Bessborough Housing Development Blackrock, Co. Cork

Stage 1 Road Safety Audit

March 2022

Client	Estuary View Enterprises Ltd. 2020				
Project Title	Bessborough Housing Development				
Document Title	ocument Title Report for Stage 1 – Road Safety Audit				
Job No. 21107TT					
Document No.	21107TT-Doc05

Drawing file: Site Drawings / SB-2020-107 401 PEDESTRIAN ACCESS GATE COMPLIANCE.pdf

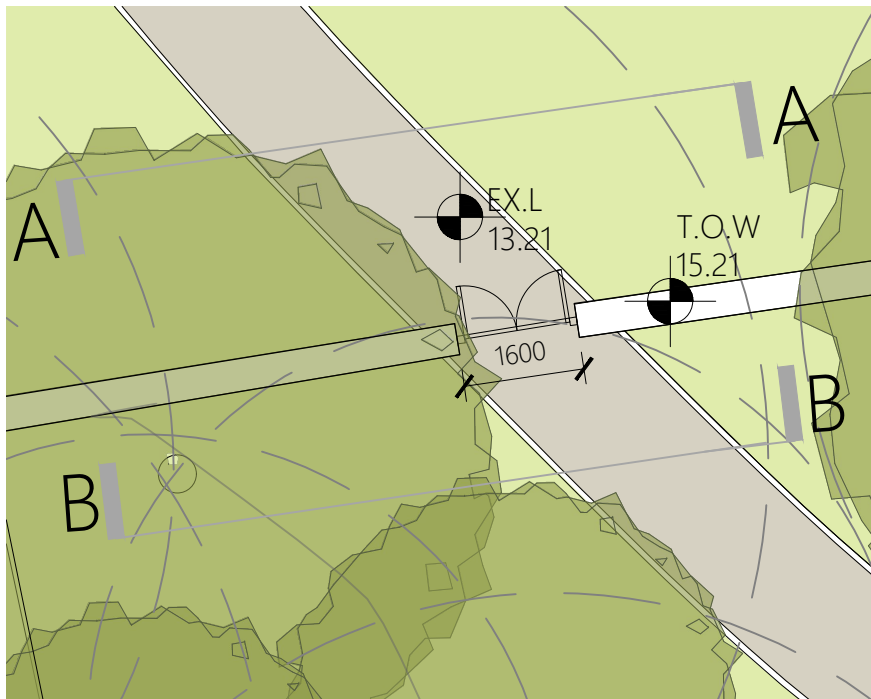
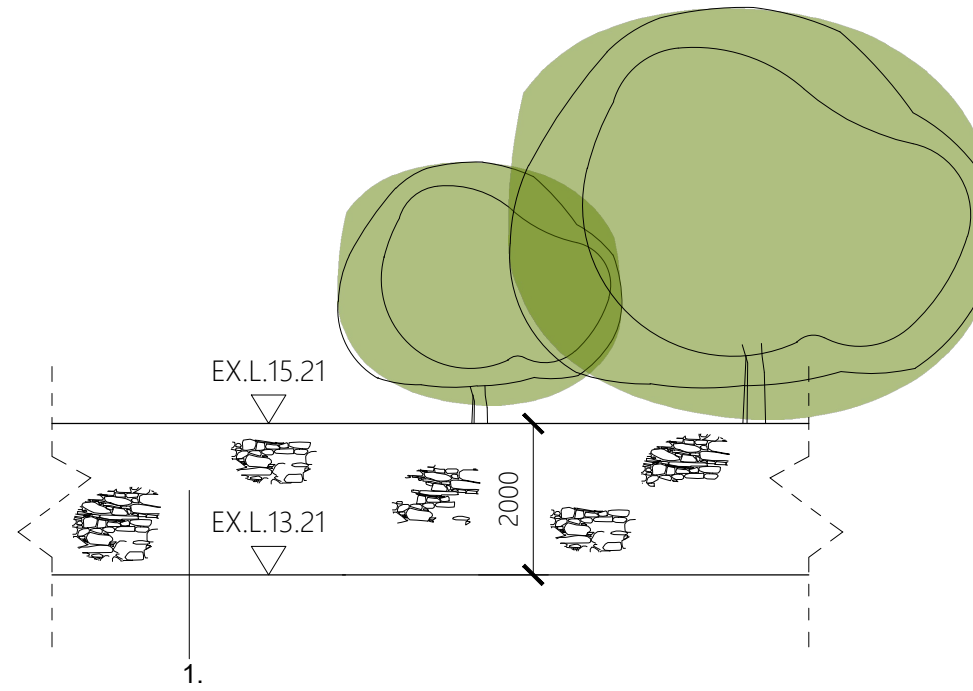
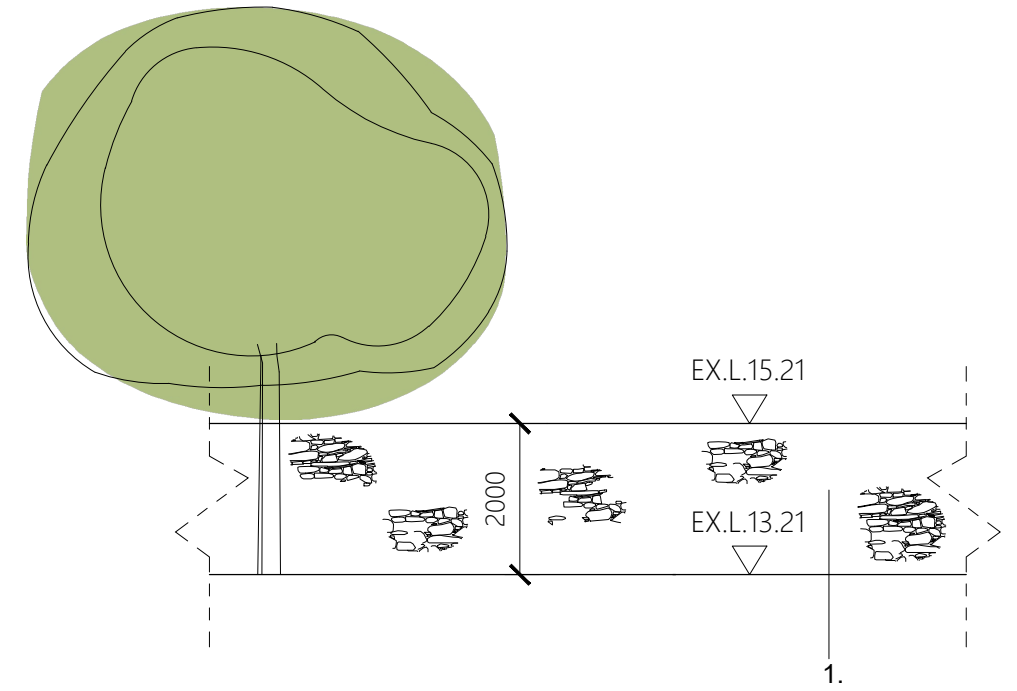
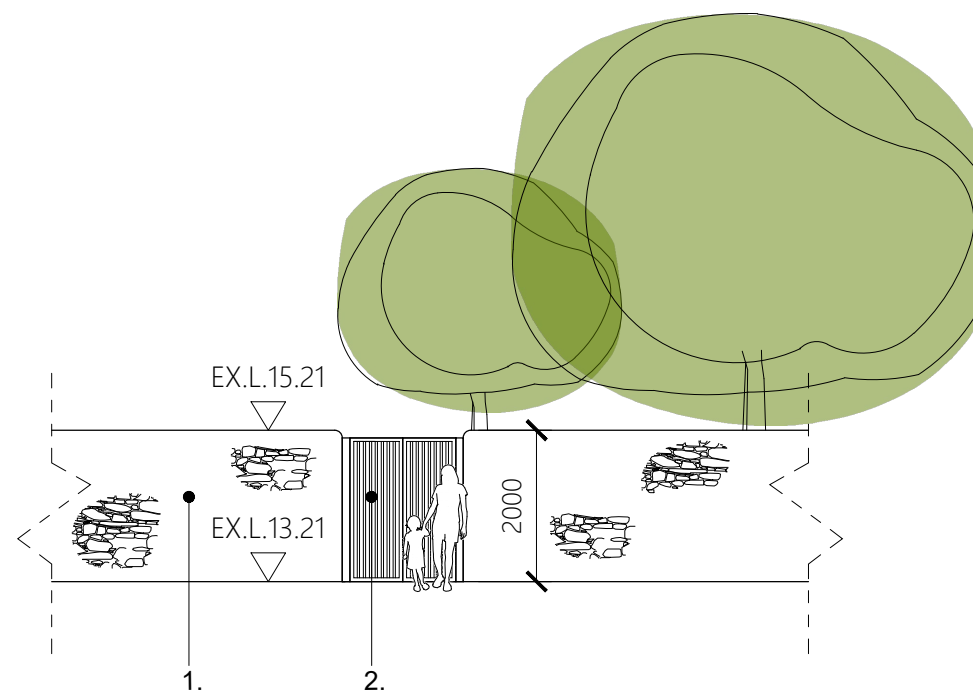
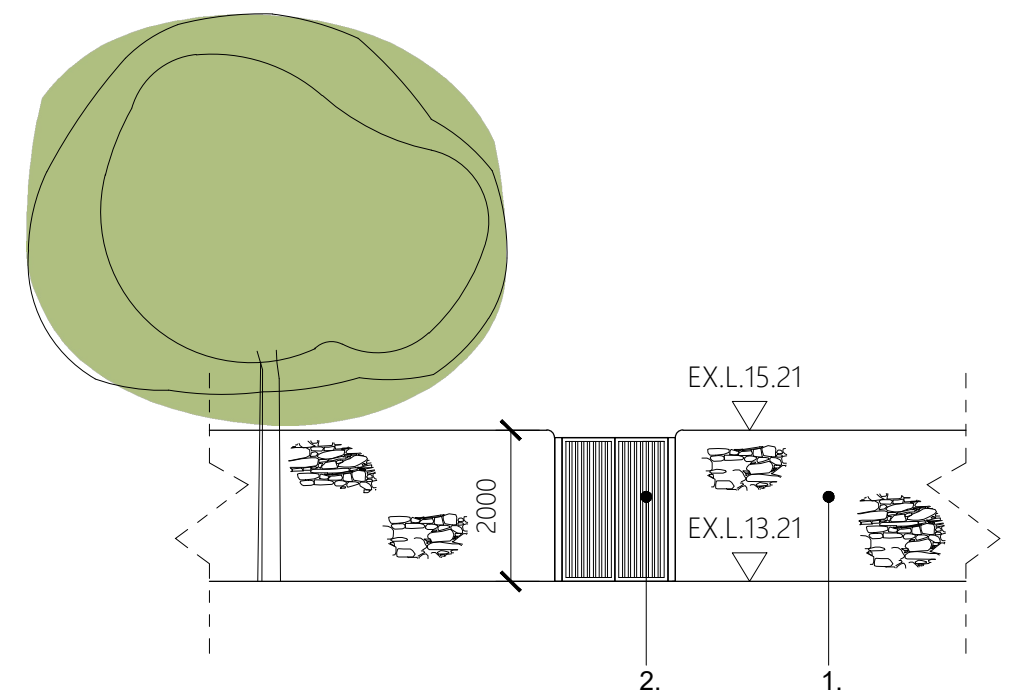
Vehicles approaching the communal amenity area gate from the east do not have clear forward visibility to the gate. This could lead to collisions between vehicles and vulnerable road users, in particular with pedestrians crossing the road to access the bike spaces directly across from the gate.

Design proposals, such as a pedestrian railing, should be considered to block the pedestrian desire line to the bike spaces across the road. Pedestrians crossing at a location further west of this point will have better sightlines to/from vehicles travelling within the development.

2.3.1	Yes	Yes	Crossing provision added per recommendation . please refer drawing number: SB-2020-107-200-FARM SITE LAYOUT PLAN	
2.3.2	Yes	Yes	Guard rail provided to push desire line further west - please refer drawing number: SB-2020-107-200-FARM SITE LAYOUT PLAN
